From: Gary Ferrier [REDACTED]
Sent: 20 June 2017 17:37
To: Andrew Wood
Subject: RE: FG/198/16/PL

Can you confirm the final height of the building above the entrance to the underground car parking in the current plan PL005 REV J.

DWG. NO: **046/PL05**

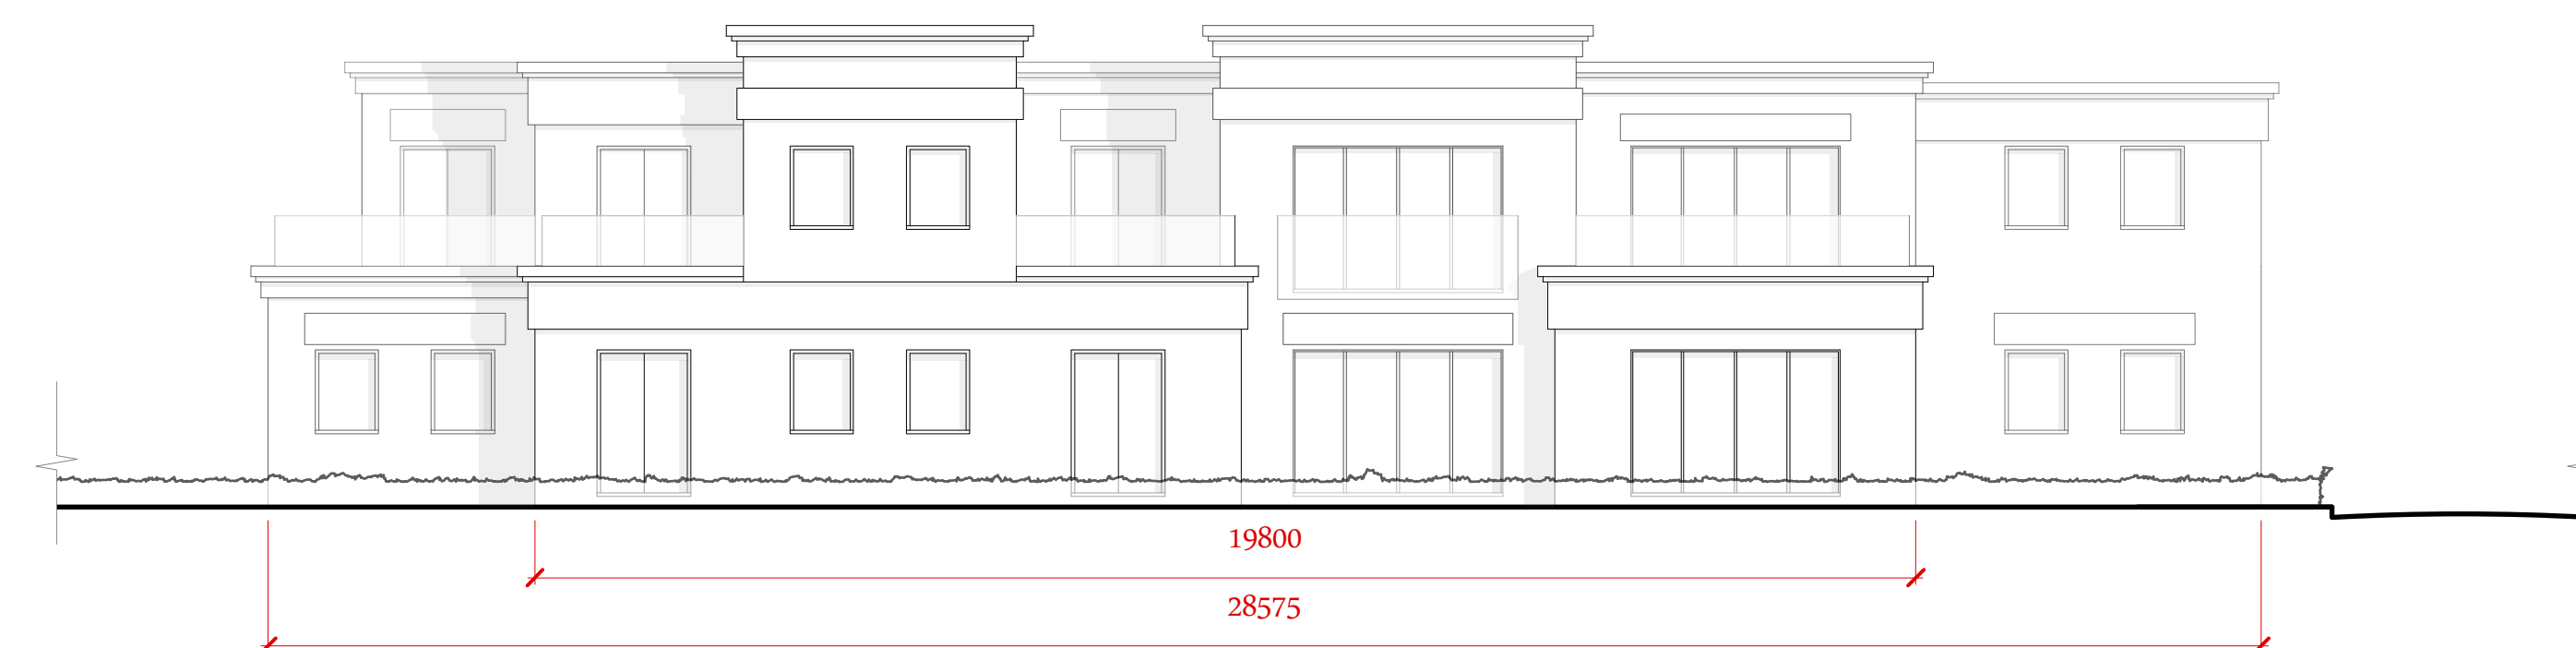
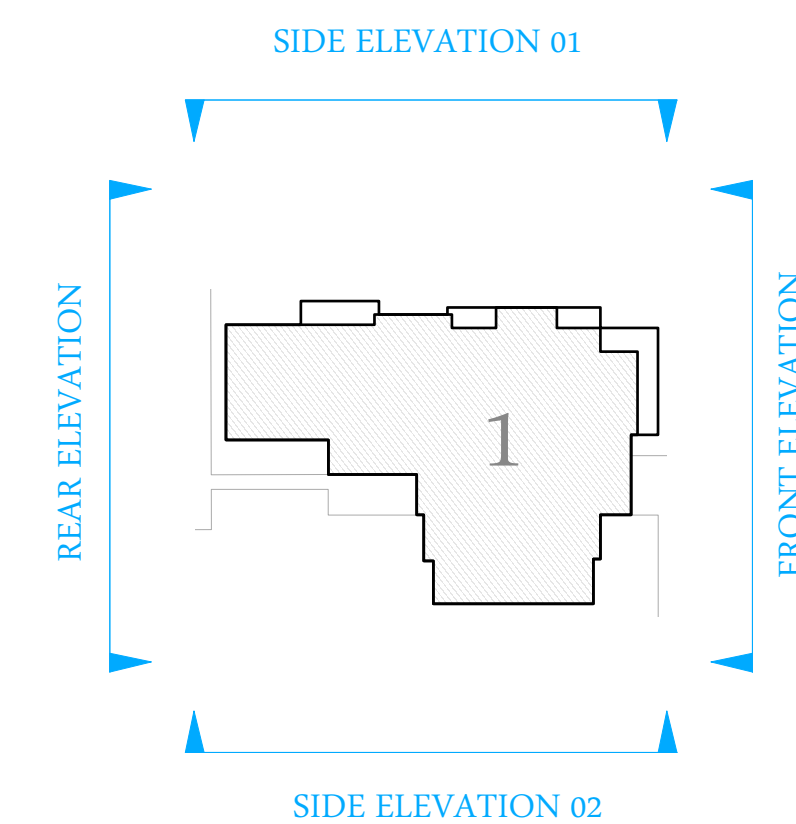
Can you please confirm if the height of the building on any party of the elevation facing onto Sea Drive rose as a result of the addition of the entrance to the underground car park.

Elevations drawing attached showing heights.

I confirm that the whole building rose by approx. 200mm to accommodate the basement parking which, incidentally, took the building FFL up to 5.800m AOD as required by the FRA.
